Your Ref: OWPC16412
Our Ref: LU/355/17/HH 20-10-2017
Please ask for:
Ross Leal

Single storey side extension to form annexe ancillary to main dwelling.
16 Madehurst Way Littlehampton

Thank you for your internet representation made on 22nd November 2017 which has been recorded as '**an objection**' with the comments as follows:

DRAWING	SCALE
PLANNING	1/100
DATE: OCTOBER 2017	
DRAWN: T. Murray	
DRAWING: 17/46/2	REVISION:

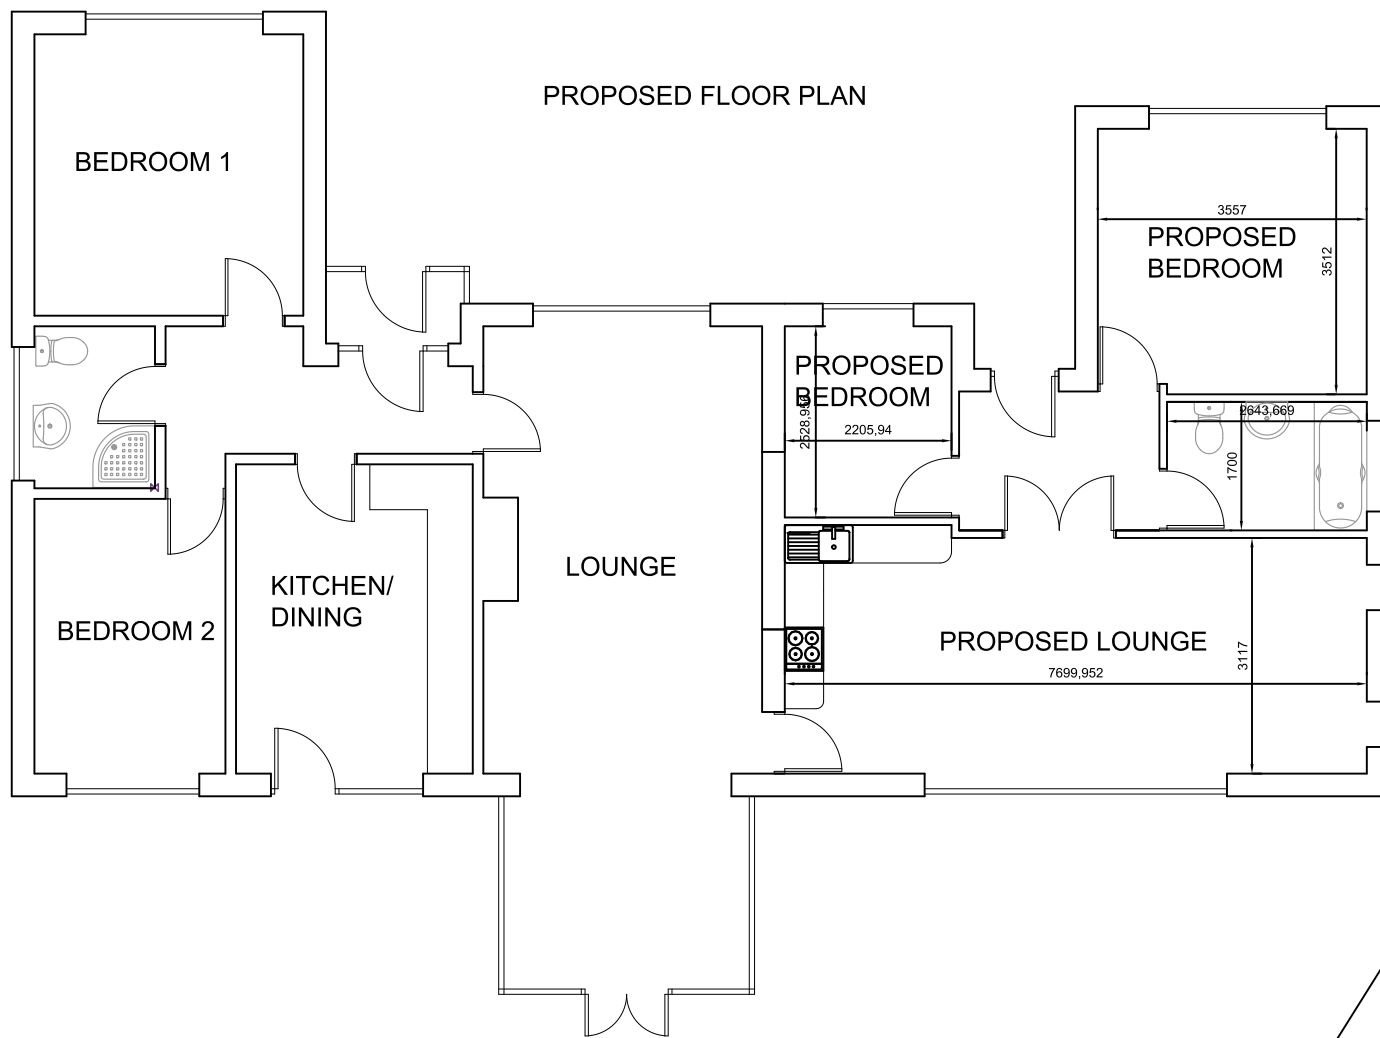
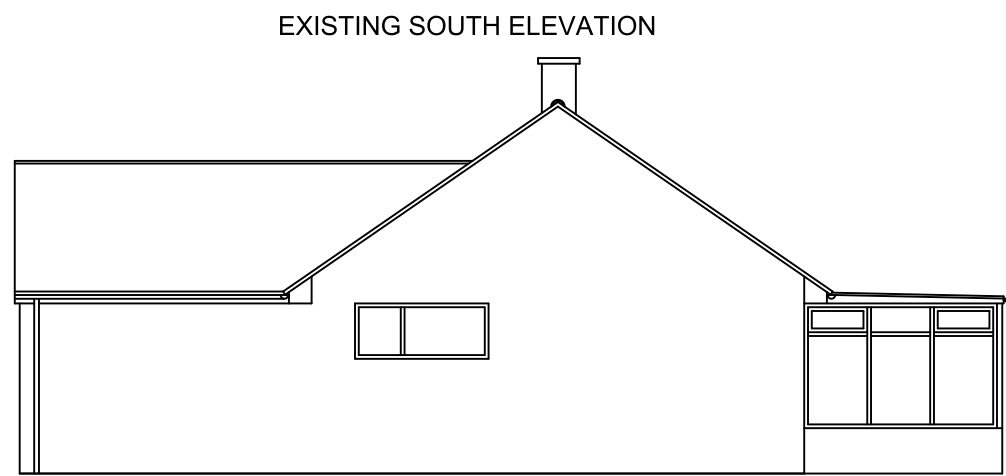
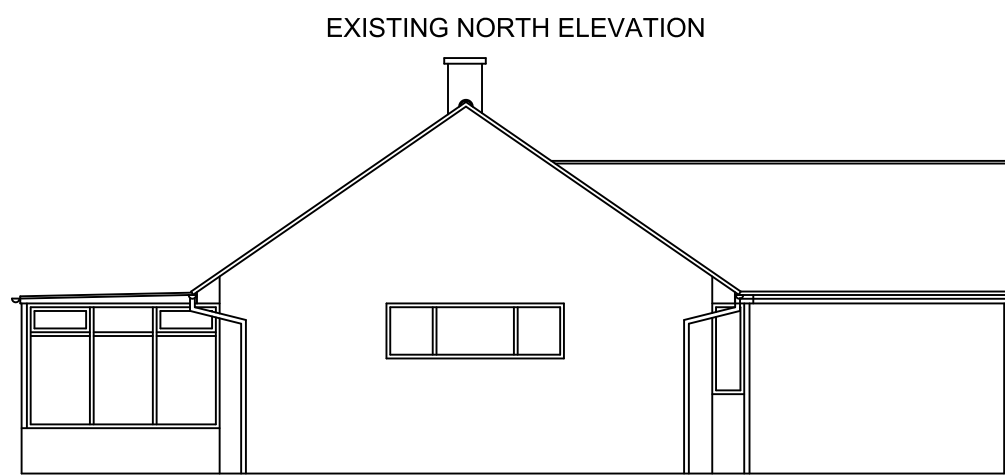
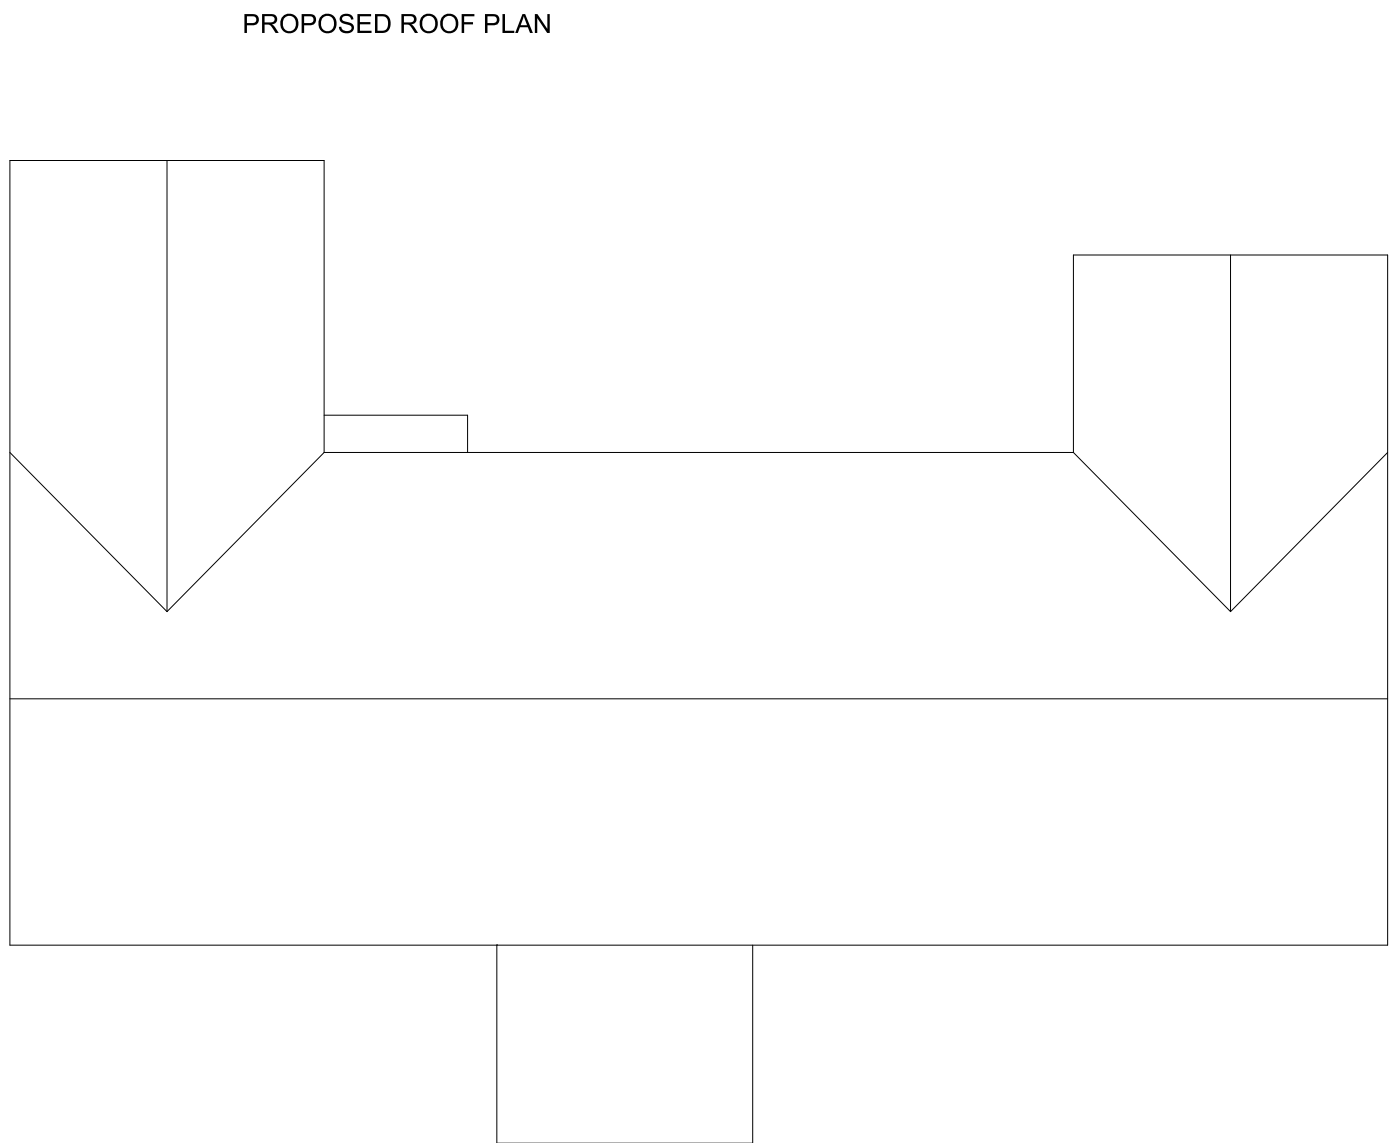
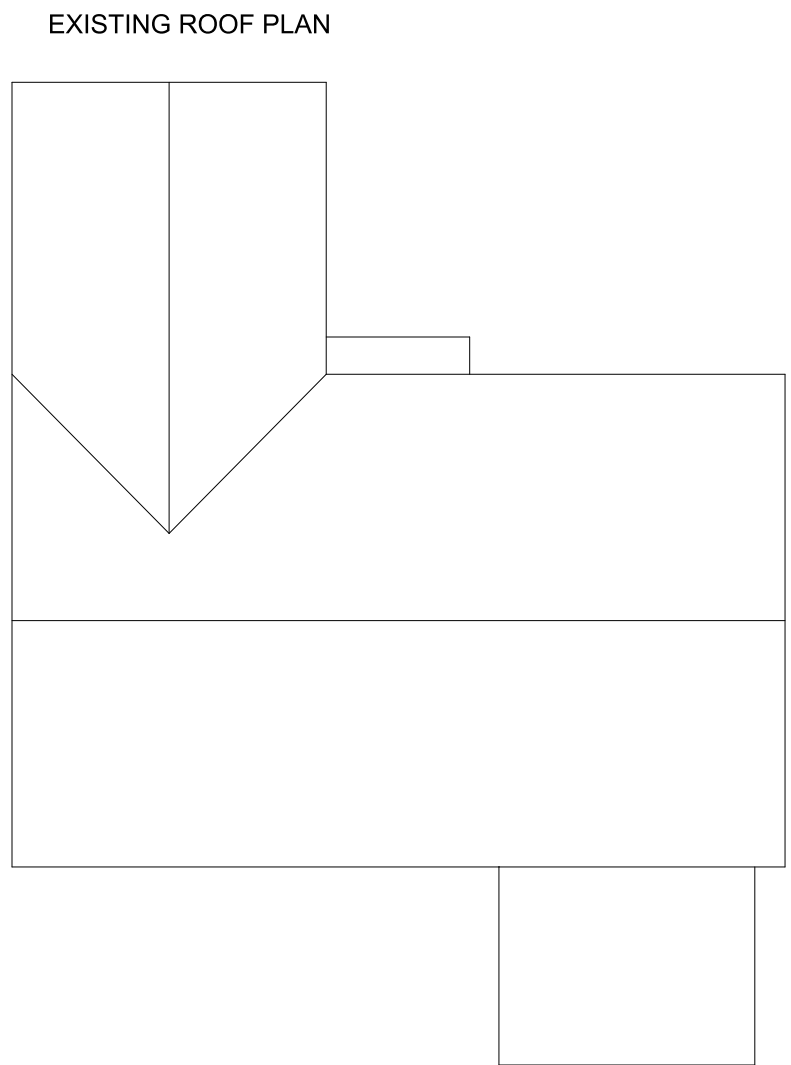
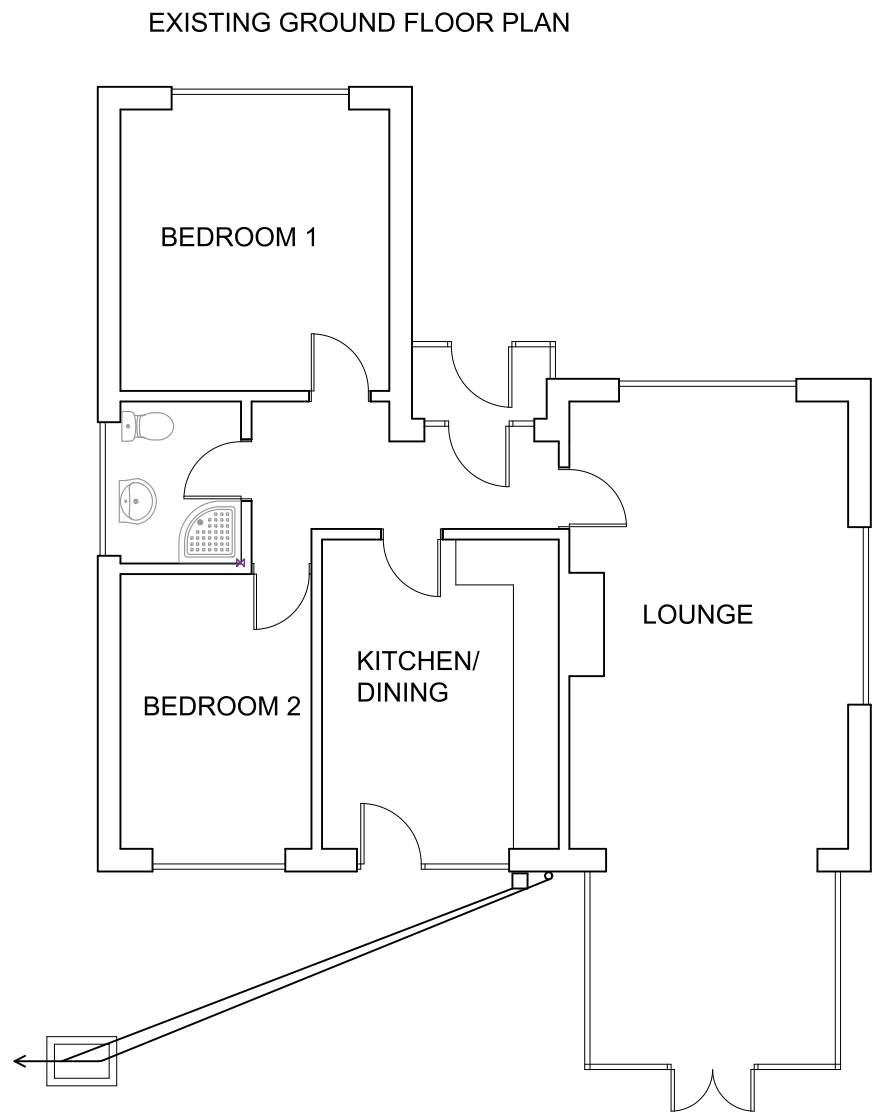
At the time of purchasing a property on what is locally known as the 'Berg Estate' I bought into the spacious design concept adopted by the original developer of the site. Restrictions were imposed limiting the height of boundary demarcations to the front of properties in order to create an 'open plan' environment. The proposed extension detracts from this 'Design Intent' so far as to encroach on the front garden and to within 380 mm. of the public pavement.

The extension comes close to doubling the floor area of the building, particularly if the extension to the original lounge is removed from the equation. The extension has an independent front door and comprises an entrance hall, lounge/diner/kitchen, two bedrooms and bathroom/toilet. It is linked to the existing building only, by a single internal door. In short, this so called 'annexe' is virtually an autonomous two bedroom dwelling. Approval of this application would set a precedent whereby opening the floodgates to future would-be developers looking to profit from shoe-treeing similar extensions into inappropriate spaces in the vicinity.
